Response to Submissions

01.06 LANDSCAPE DRAWINGS

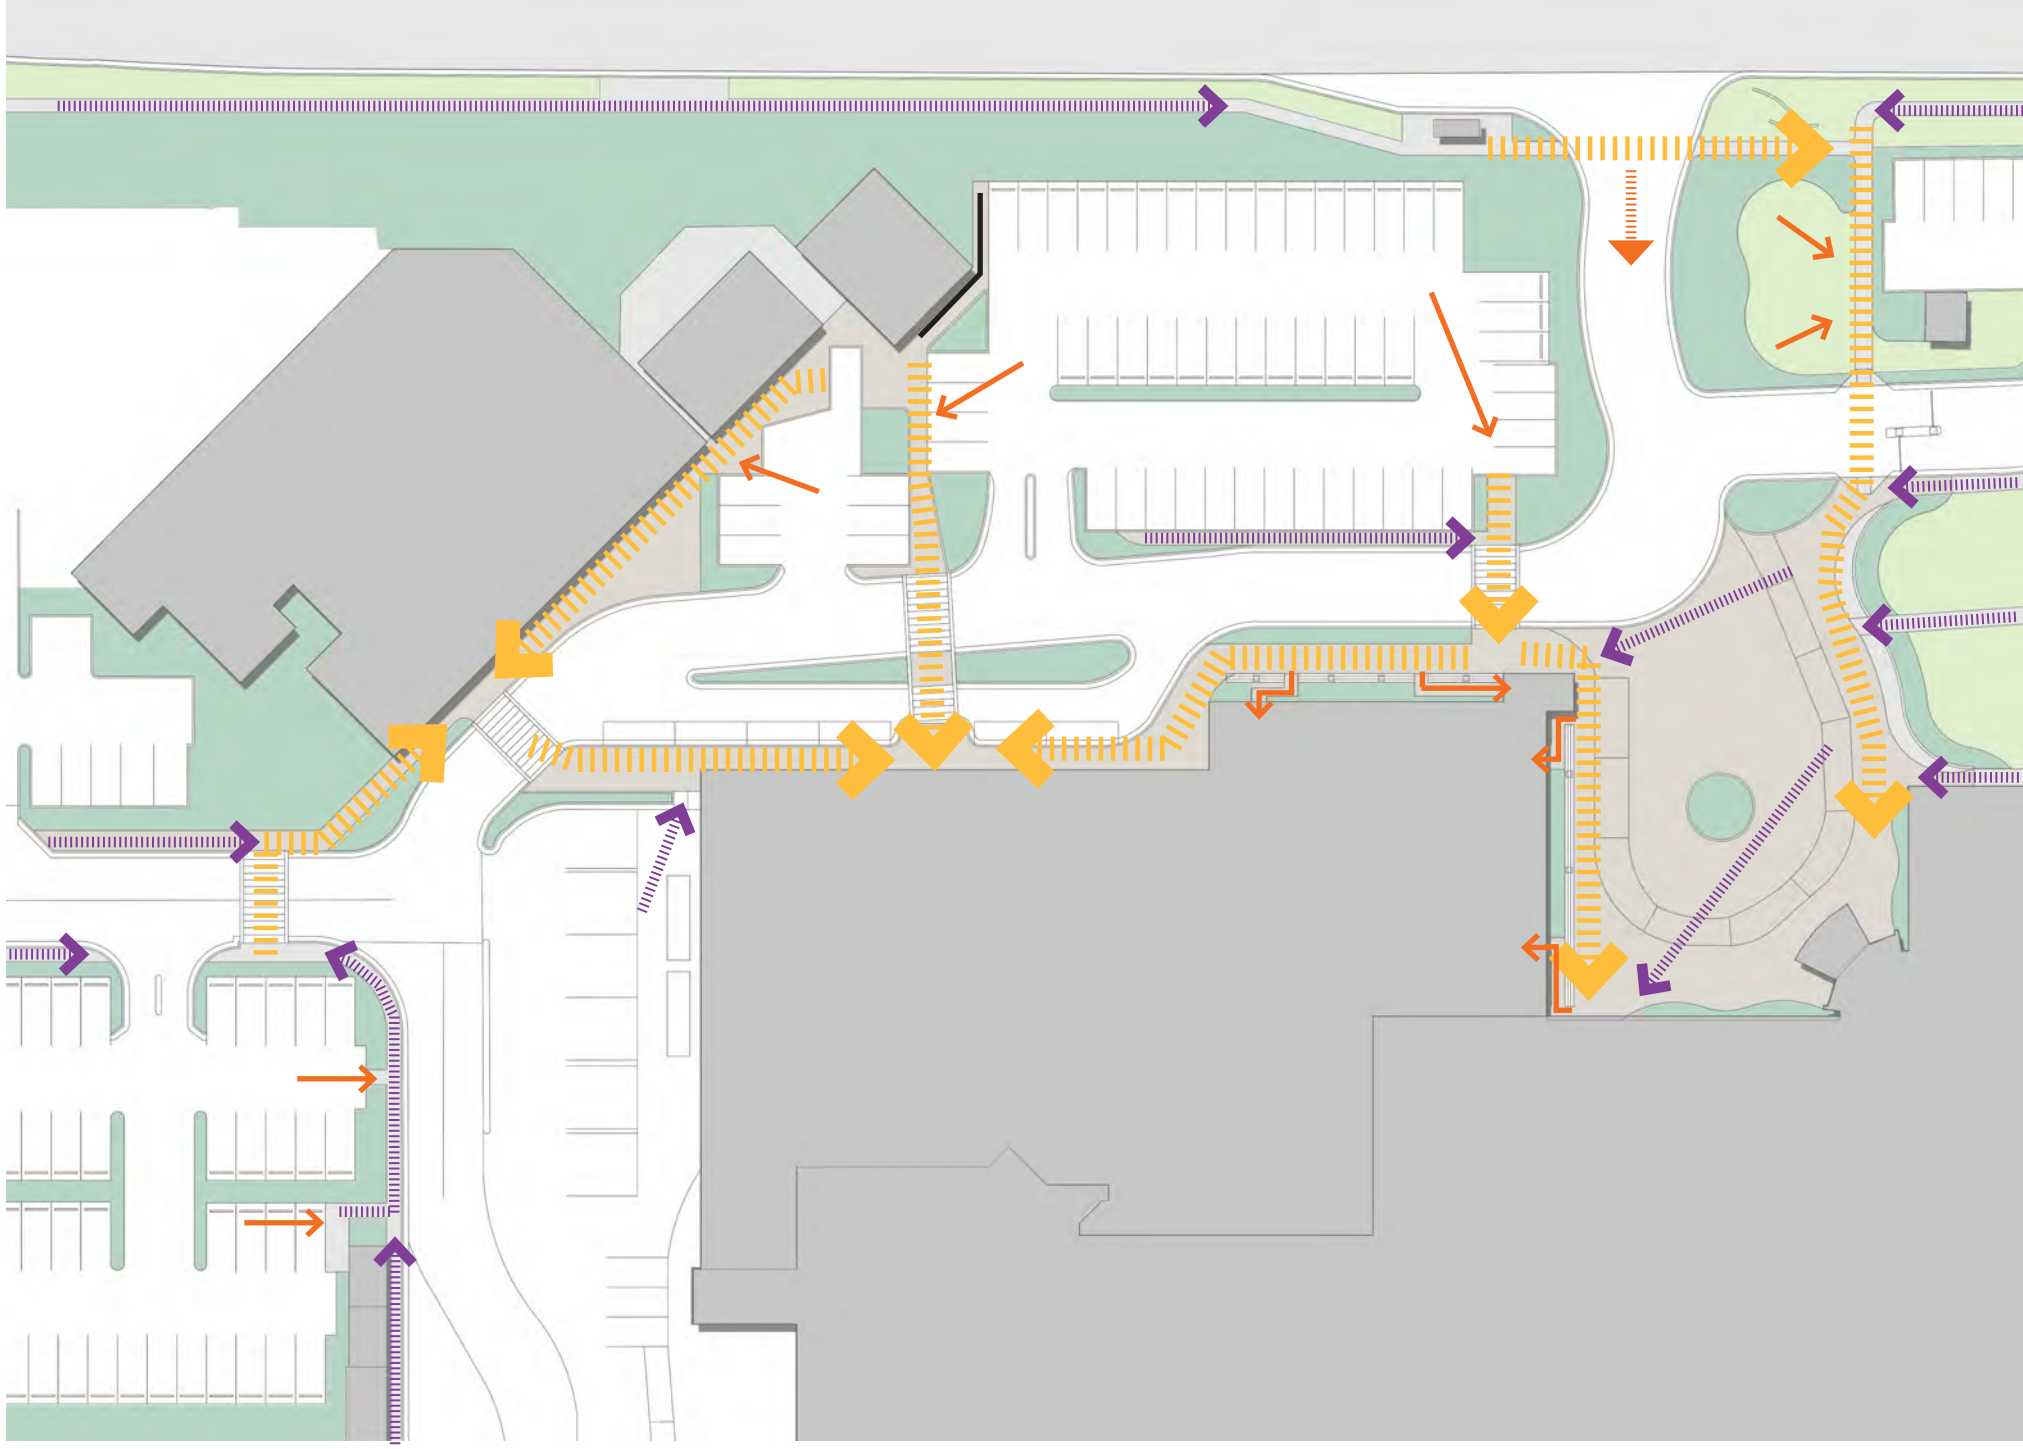
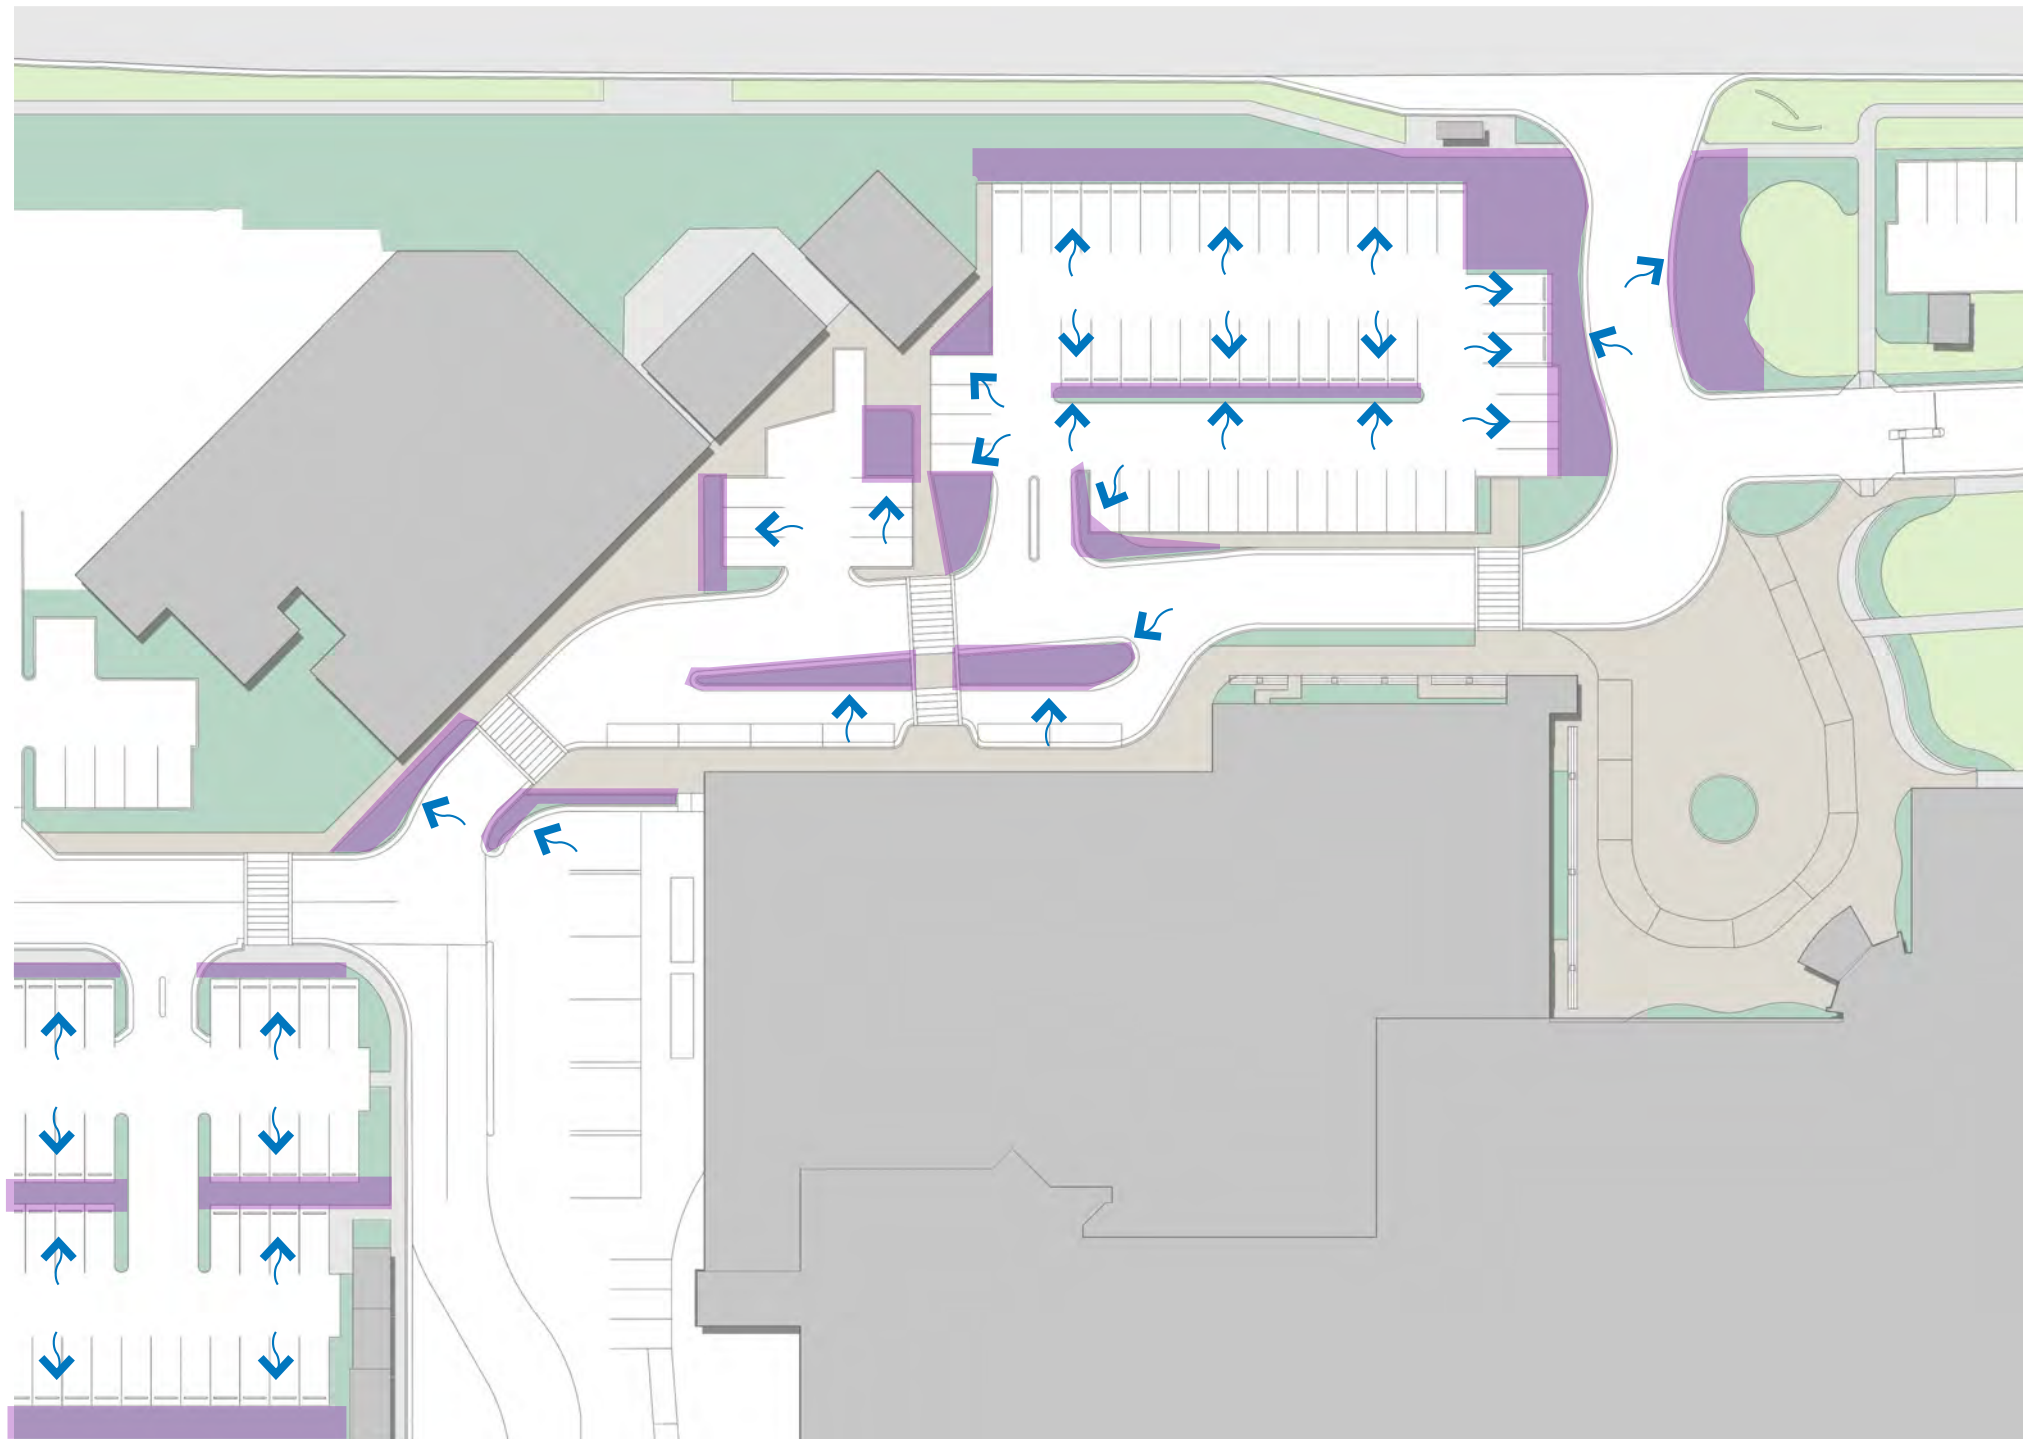
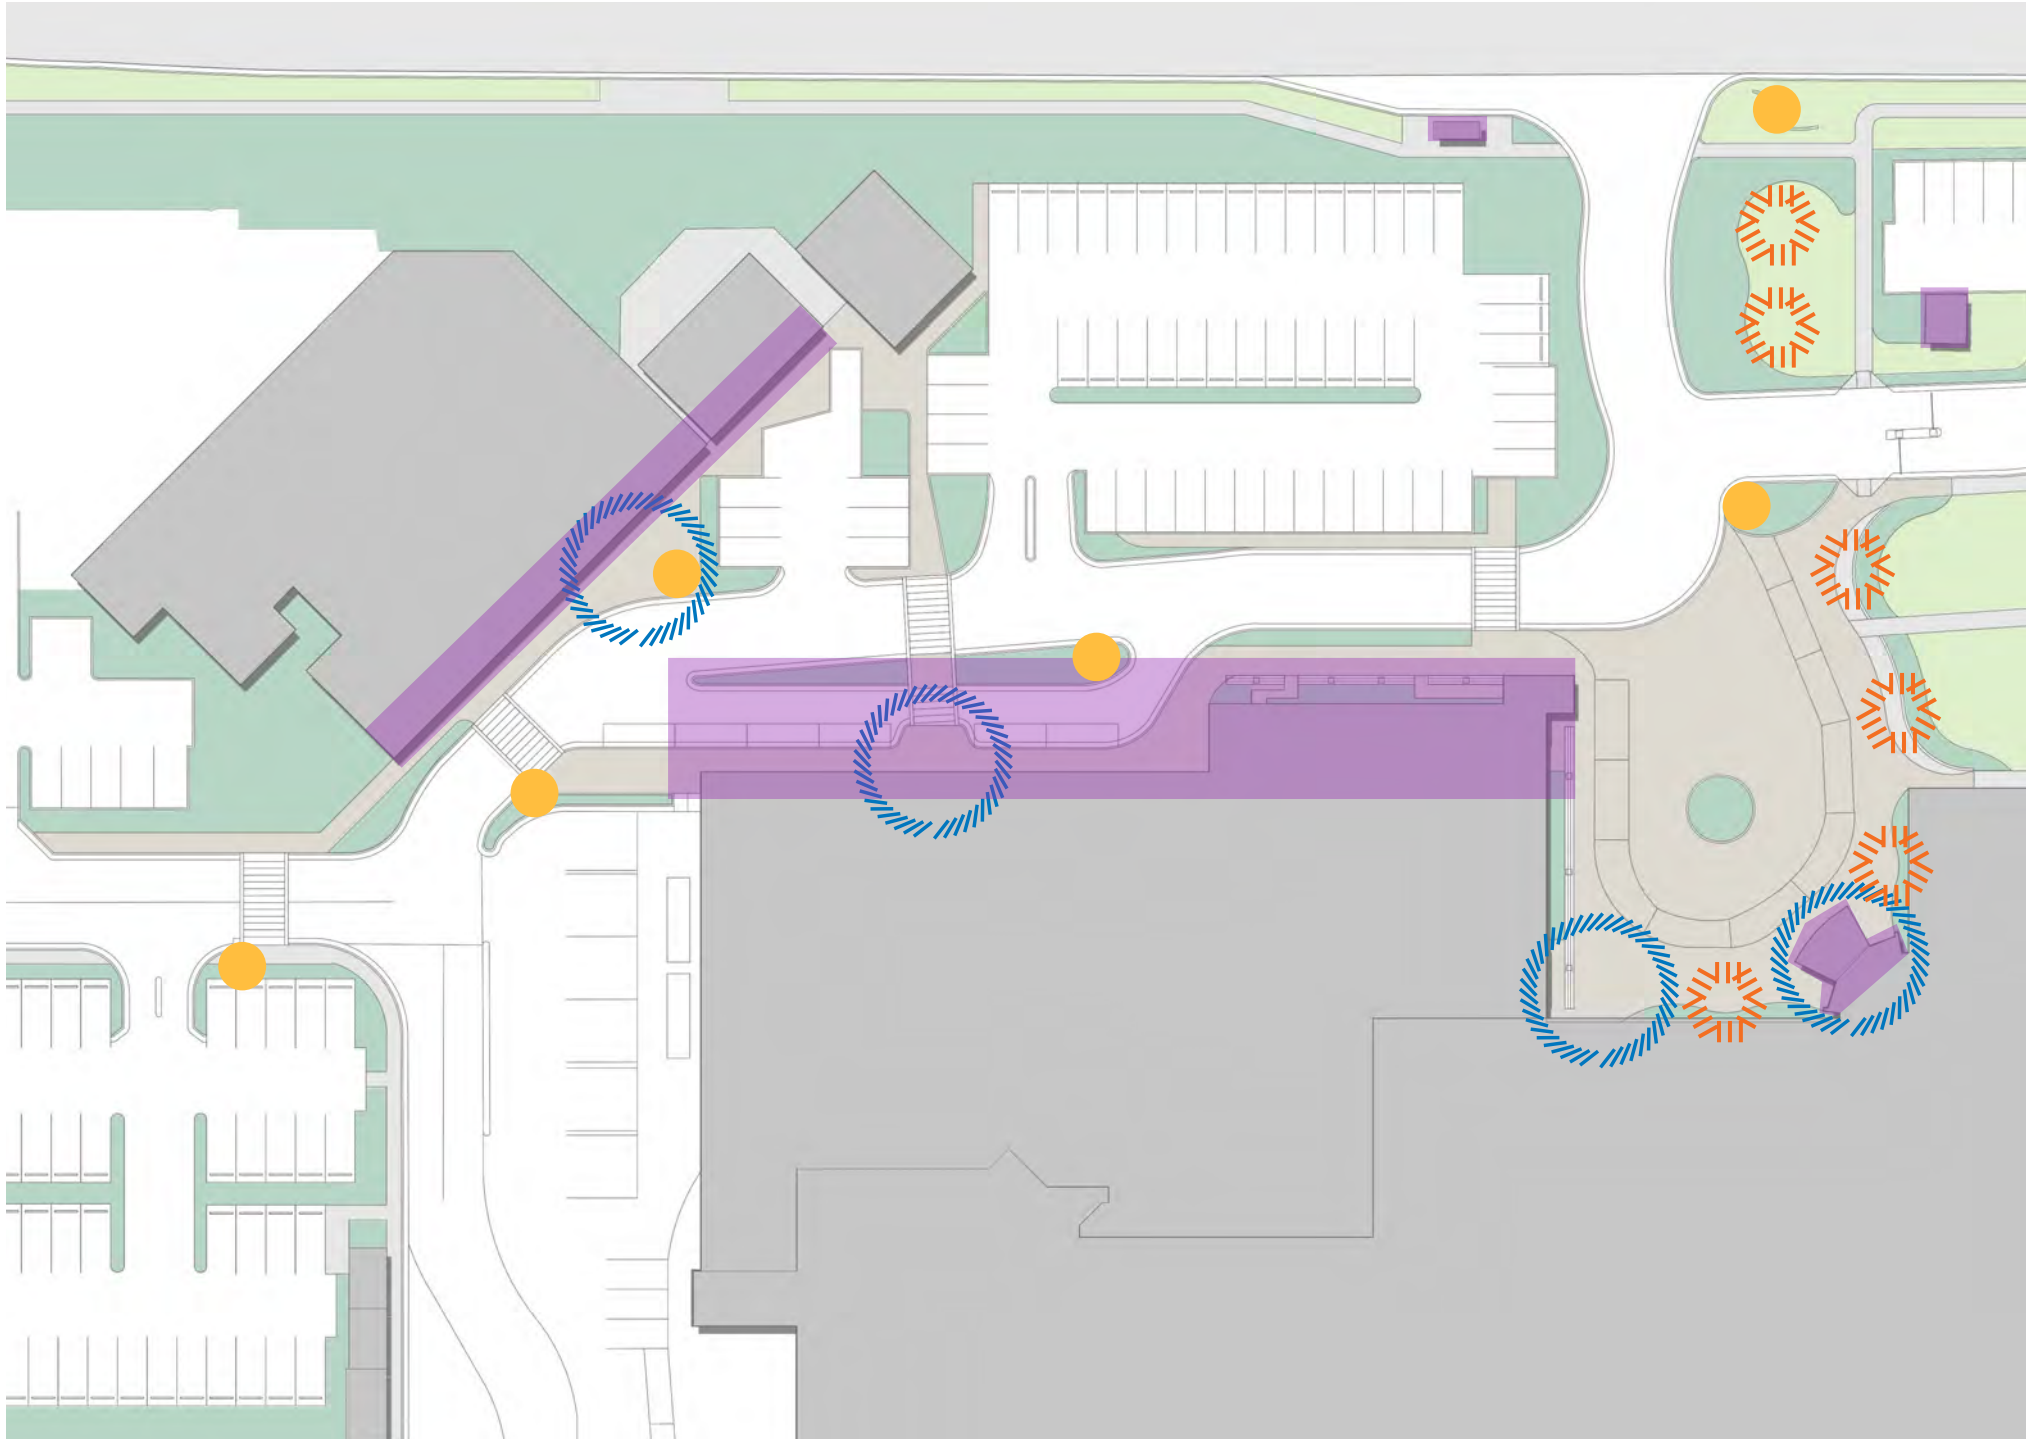
SSC	<p>Landscaping - SCC requests that indigenous tree planting be continued along the eastern section of the Kingsway between the</p>	<p>Amended landscape plans have been prepared by Arcadia to address this issue – refer Attachment 4.</p>
